Current Zoning: R-9 (CD) (Single Family Residential, Conditional)  
 Proposed Zoning: N2-A (CD) (Neighborhood 2, Conditional)

Approximately 19.16 acres located west of Nations Ford Road, south of Forest Point Boulevard, and north of Short Hills Drive.

The petition proposes a community of up to 72 multi-family attached residential dwelling units on a vacant, wooded property in the Nations Ford Road corridor.

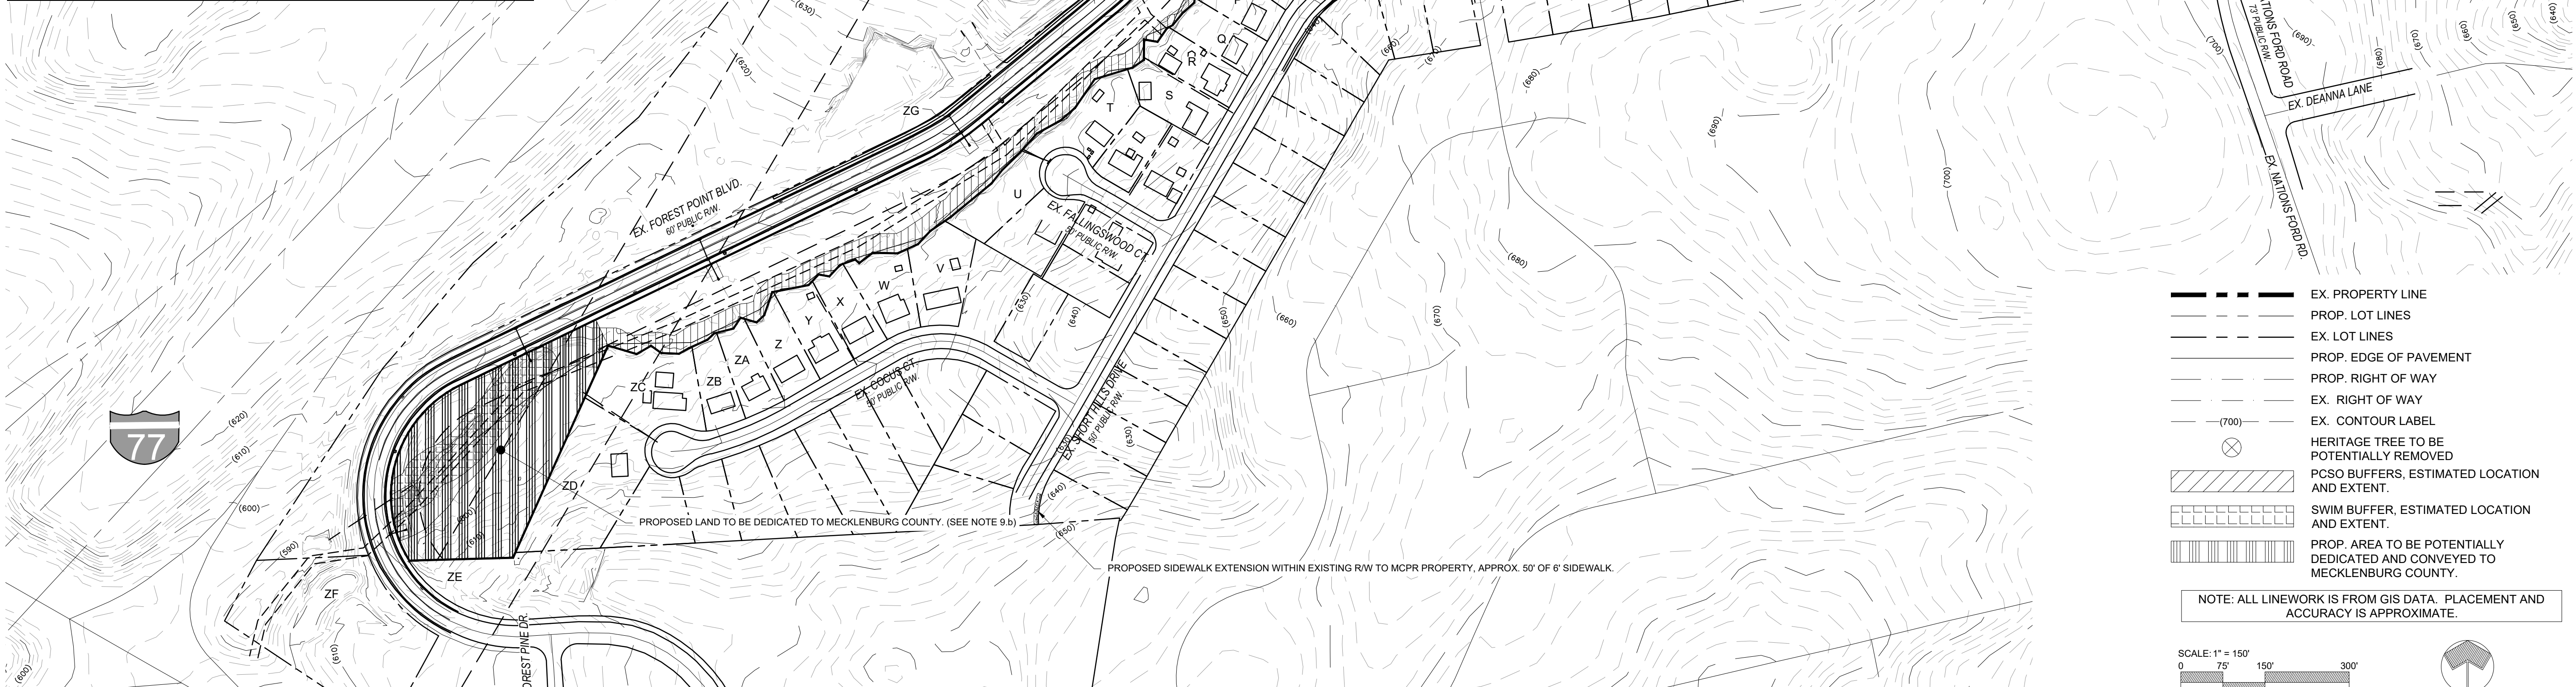
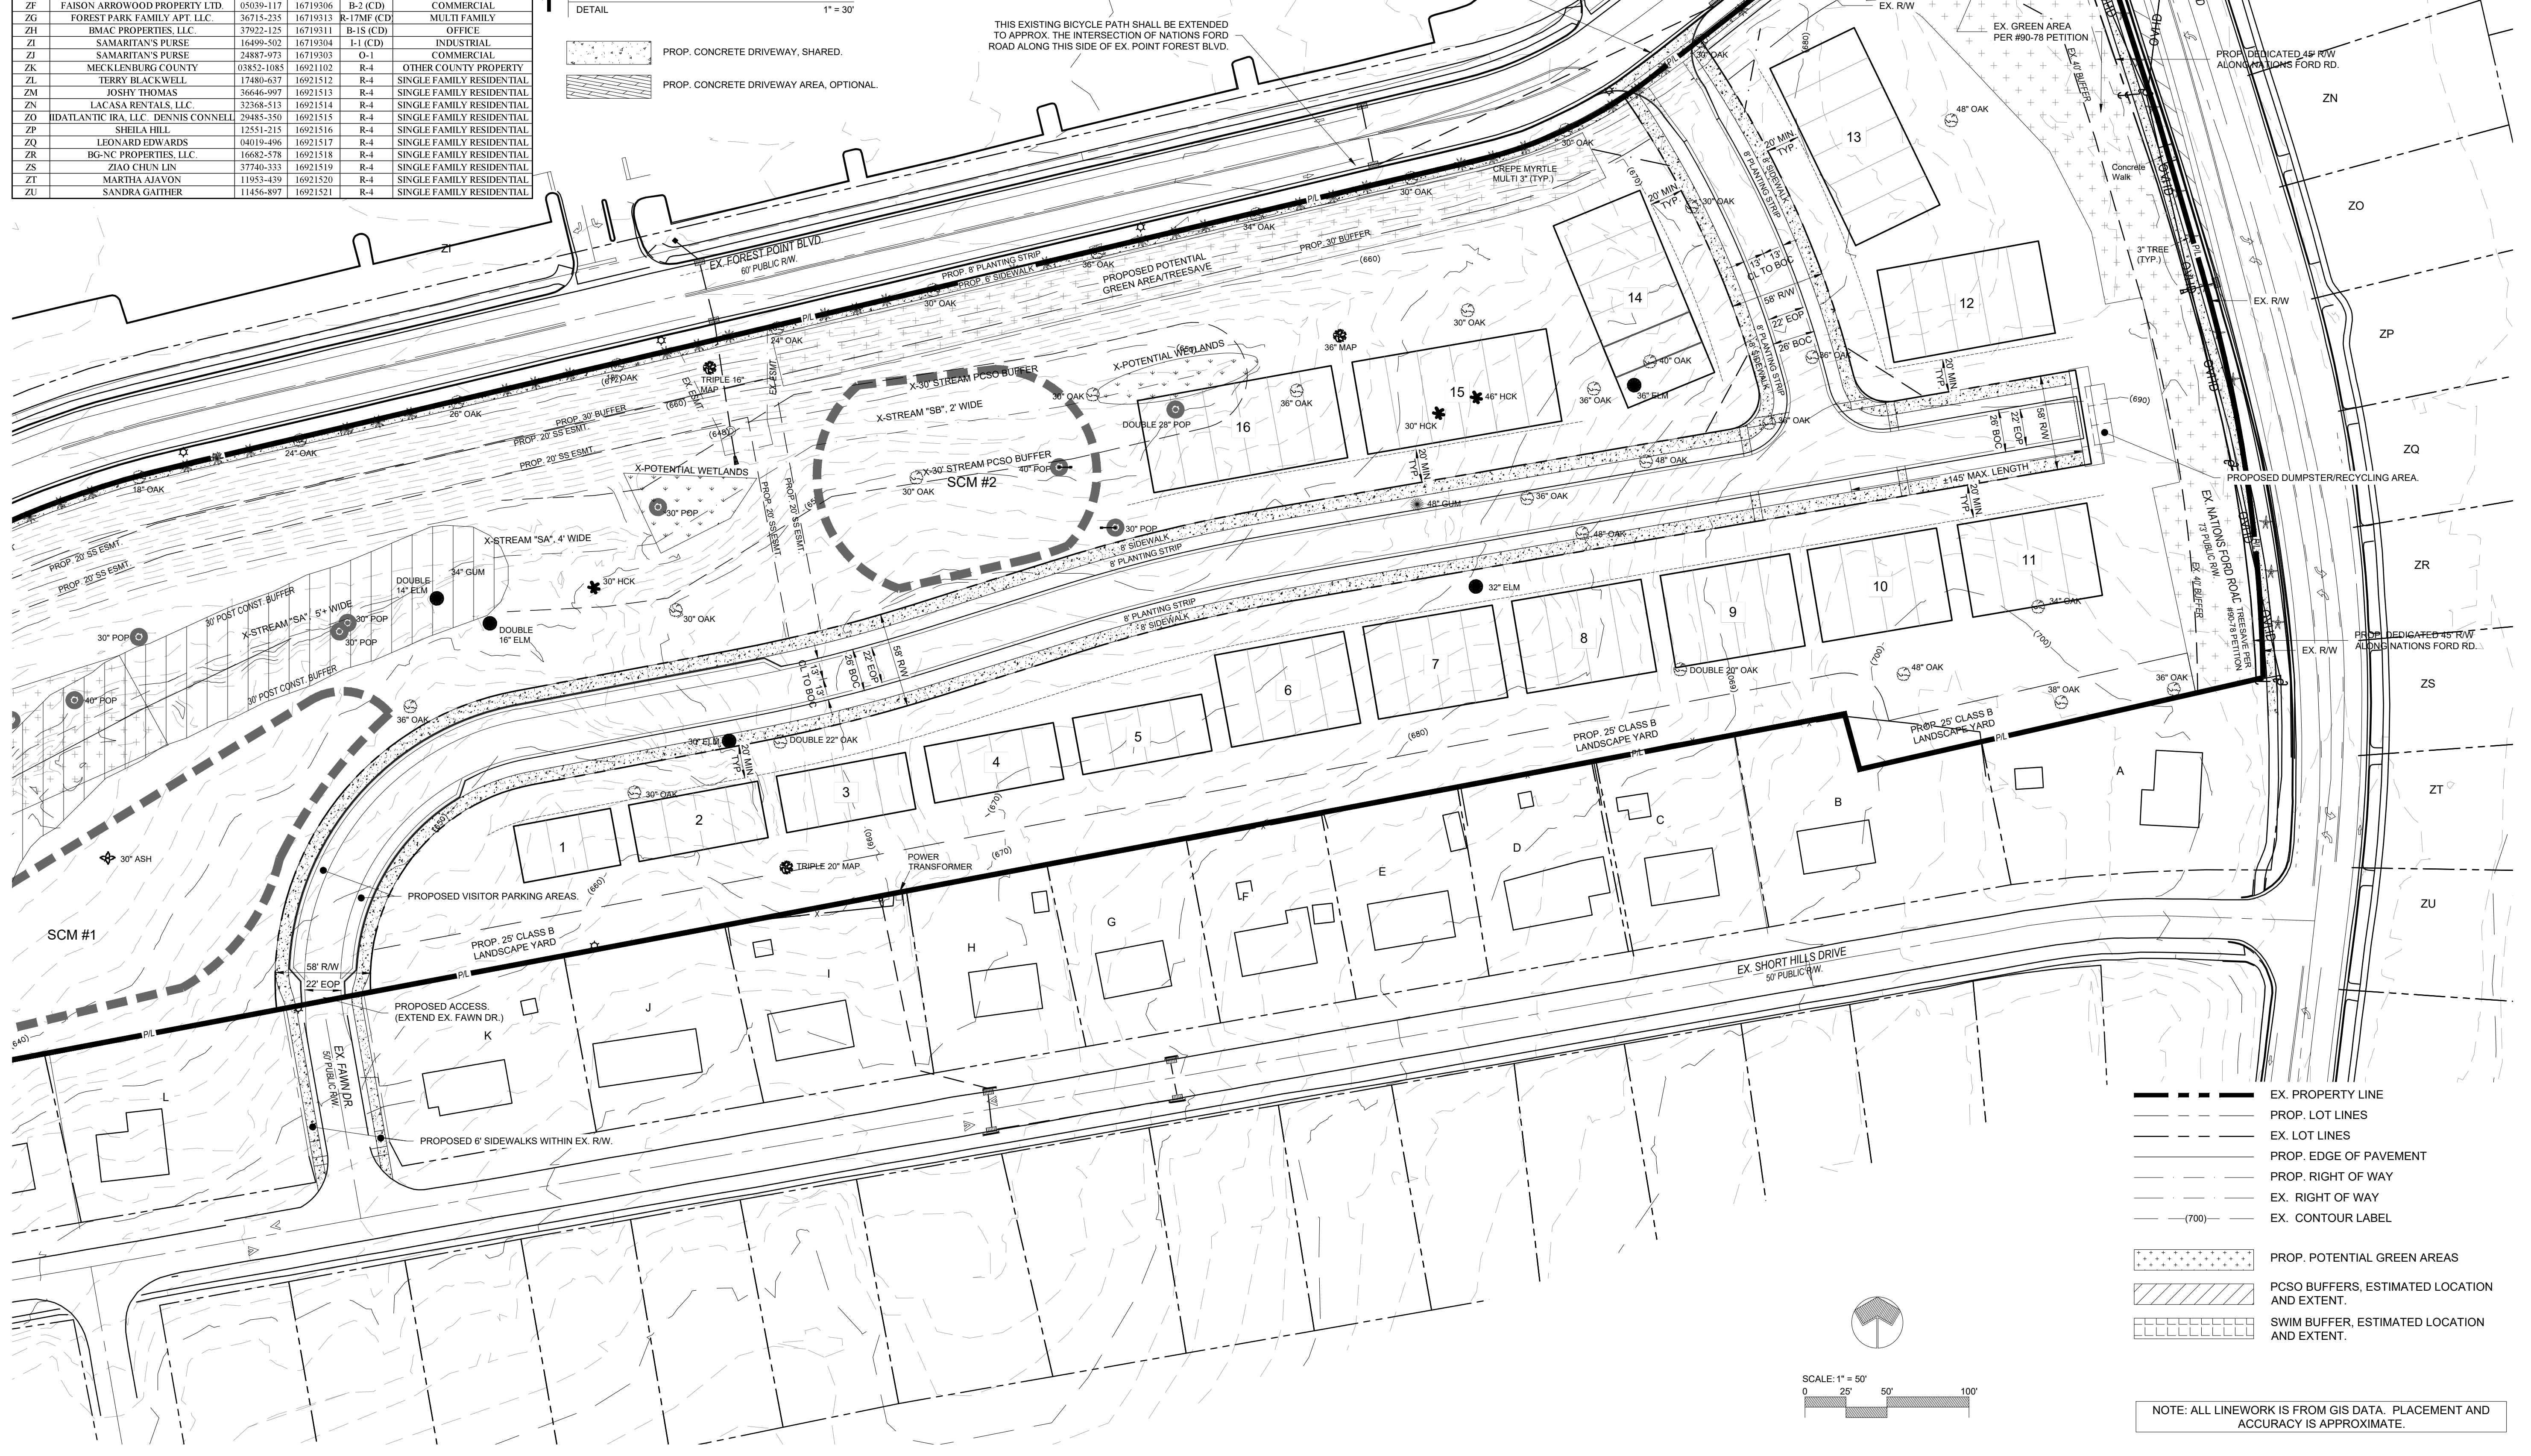
1. ~~From the centerline of Forest Point, label and dimension the ROW and back of curb.~~ **ADDRESSED**
2. ~~Edit note 5.f to reflect 50'x50' sight triangles as opposed to 35'x35'.~~ **ADDRESSED**
